23 December 2020

The Examining Authority Case Team  
Aquind Interconnector Project  
National Infrastructure Planning  
Temple Quay House  
2 The Square  
Bristol  
BS1 6PN

**DCO Application for the Aquind Interconnector Project  
SDNPA Deadline 6 Submission**

Figure 15.49: Indicative Landscape Mitigation Plan Option B(1) (south)

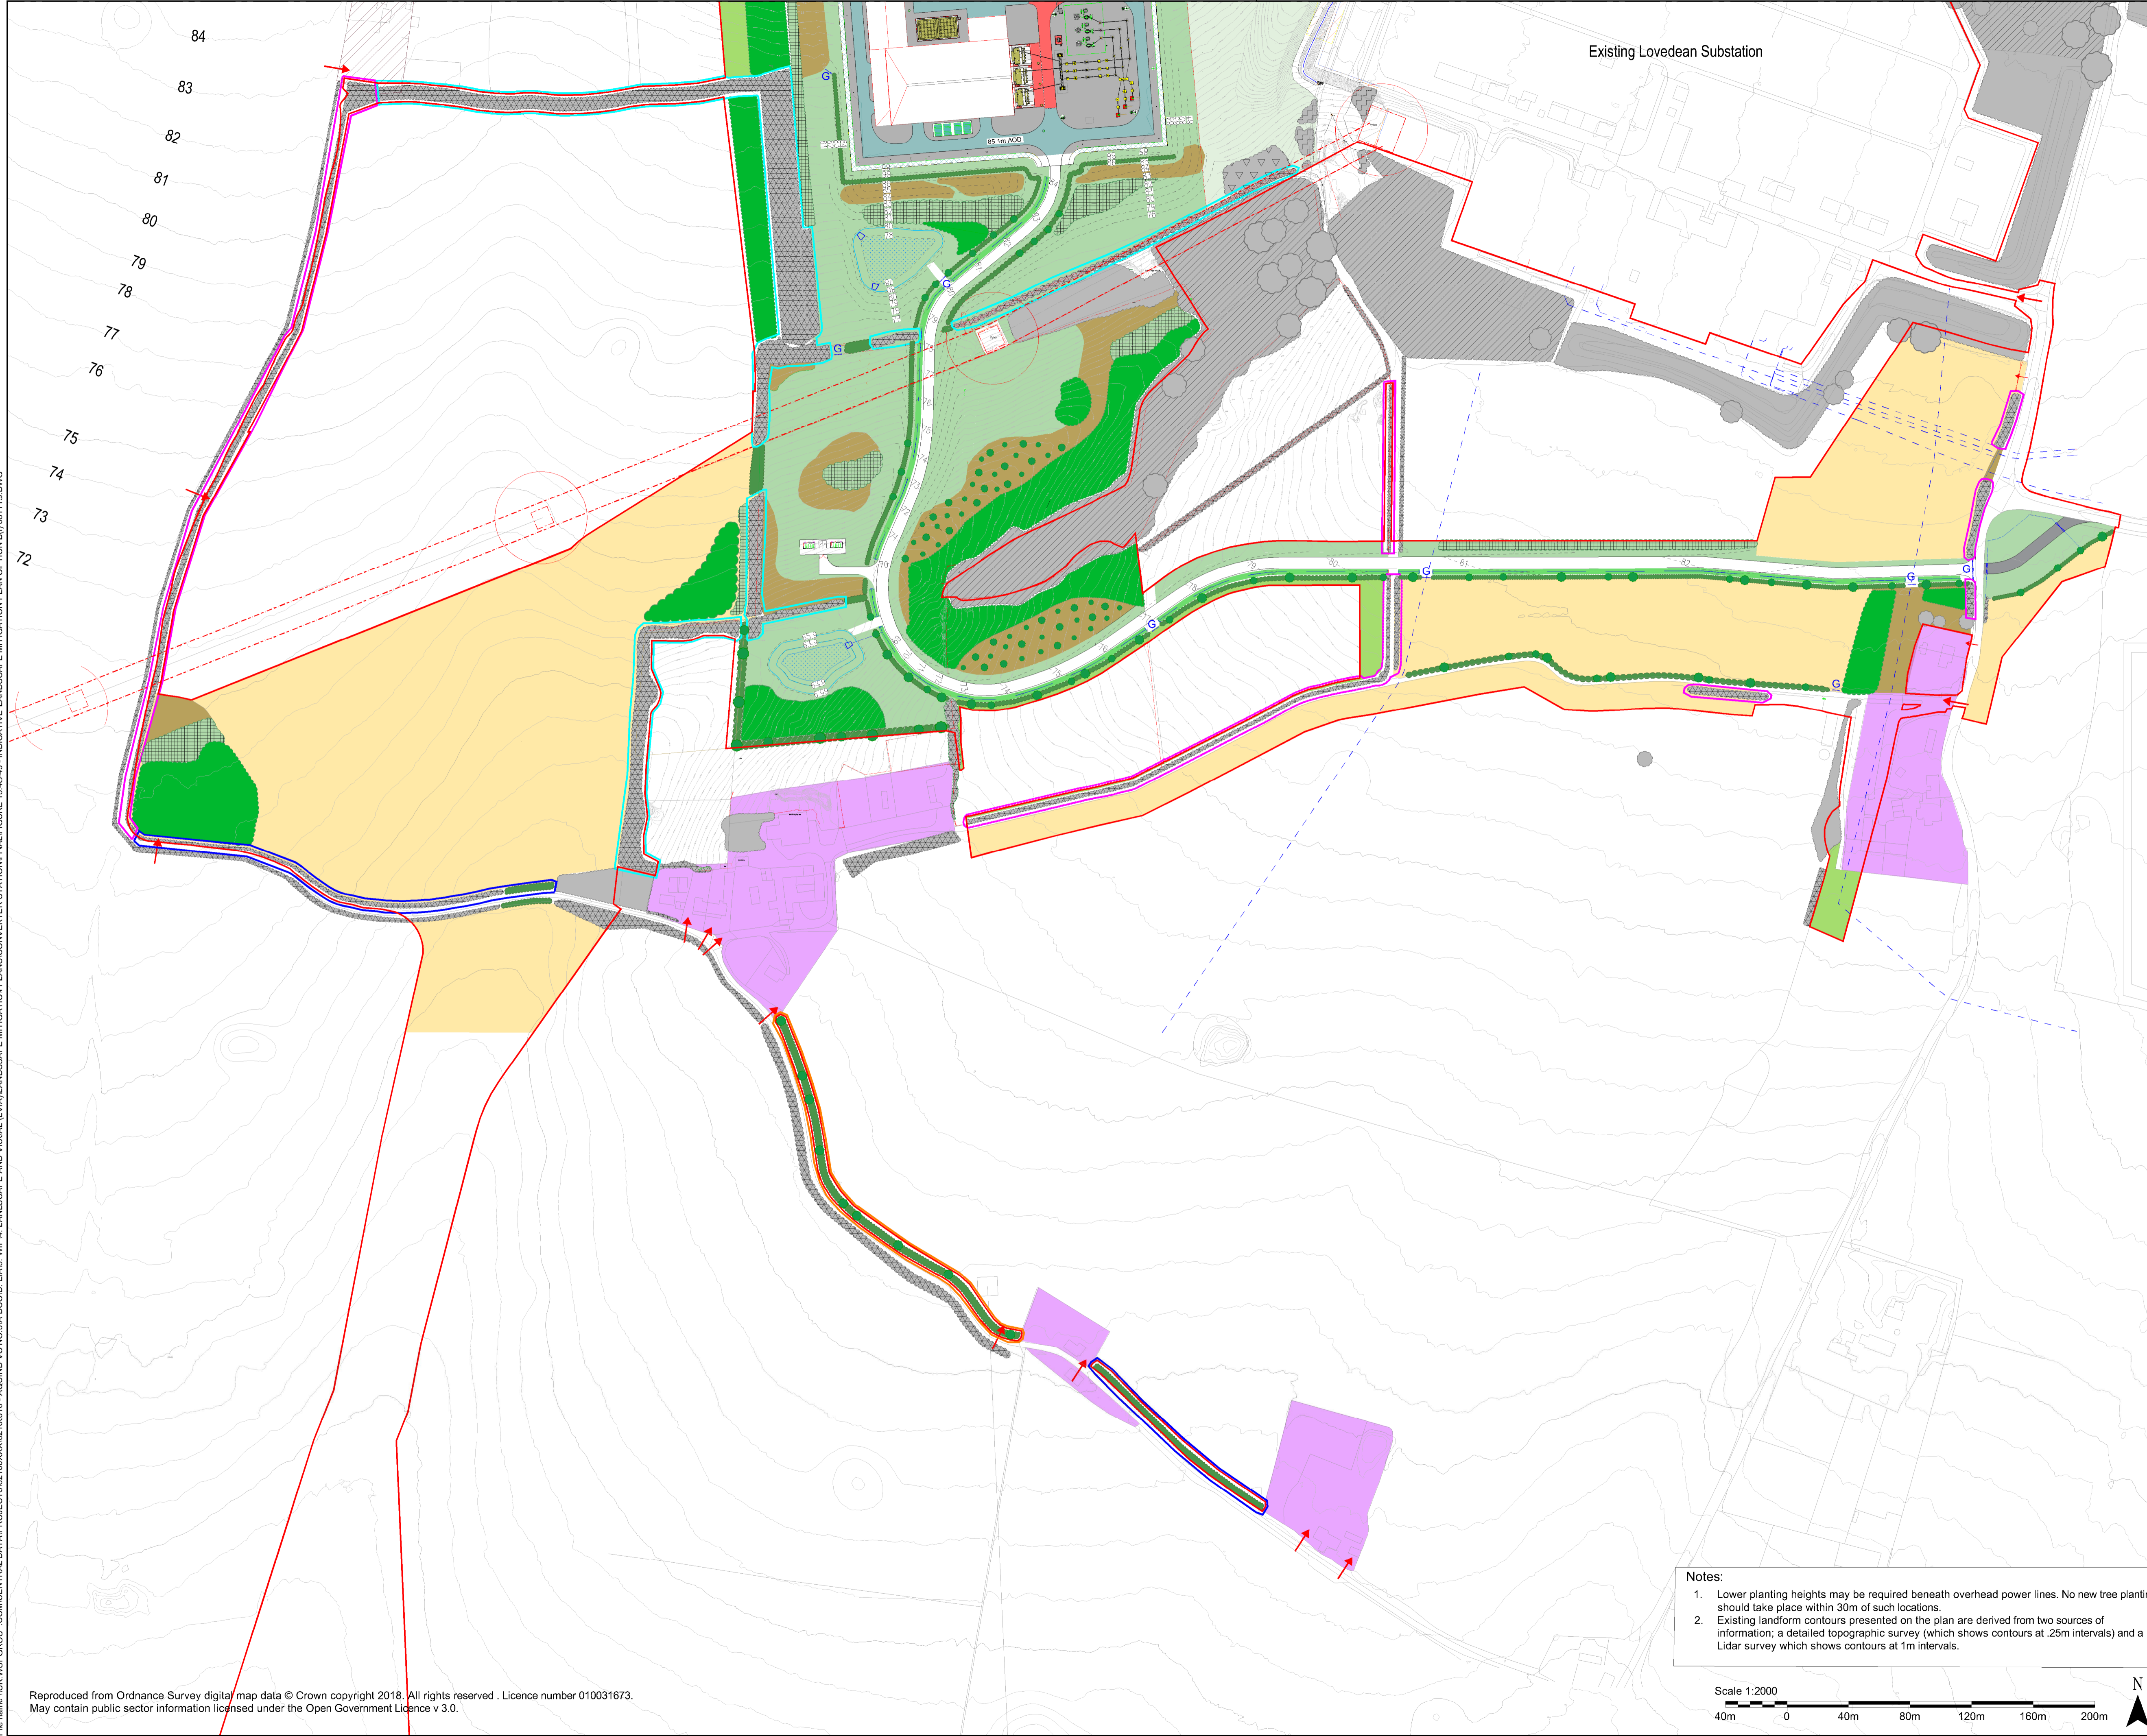
This submission from the applicant does little to address the concerns raised by the SDNPA about the landscape mitigation proposed. The additional areas proposed for woodland planting are very small and located solely to the south of the Converter Station.

The SDNPA understand the operational constraints relating to planting in close proximity to the Converter Station, but is still concerned at the lack of more substantial woodland planting in areas further away from the Converter Station, which would also assist in combatting the likely degradation of the landscape through the creation of smaller field areas not viable for agricultural purposes.
